Planning Application Ref: AL/115/17/OUT

Location: Land surrounding Wings (Wings Nursery), Lidsey Road, Aldingbourne

Description of works: Outline Planning Application seeking approval for redevelopment of the site for 55 residential dwellings.

Comments On Application:

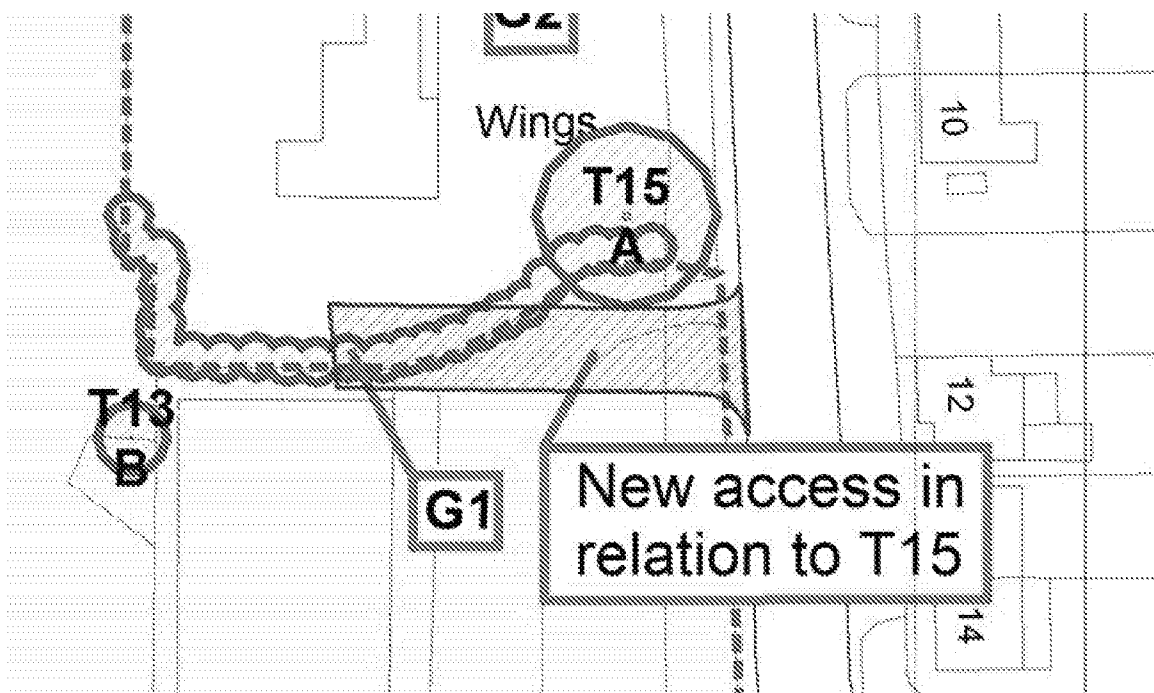
- The new access would mean the loss of an A high graded Oak tree (T15 in the Beechdown survey) and this is not acceptable.
- The layout would see the loss of T12 & T13 which are good young Oaks with future potential – I would expect to see mitigation plantings for these losses – perhaps in the central open space area?
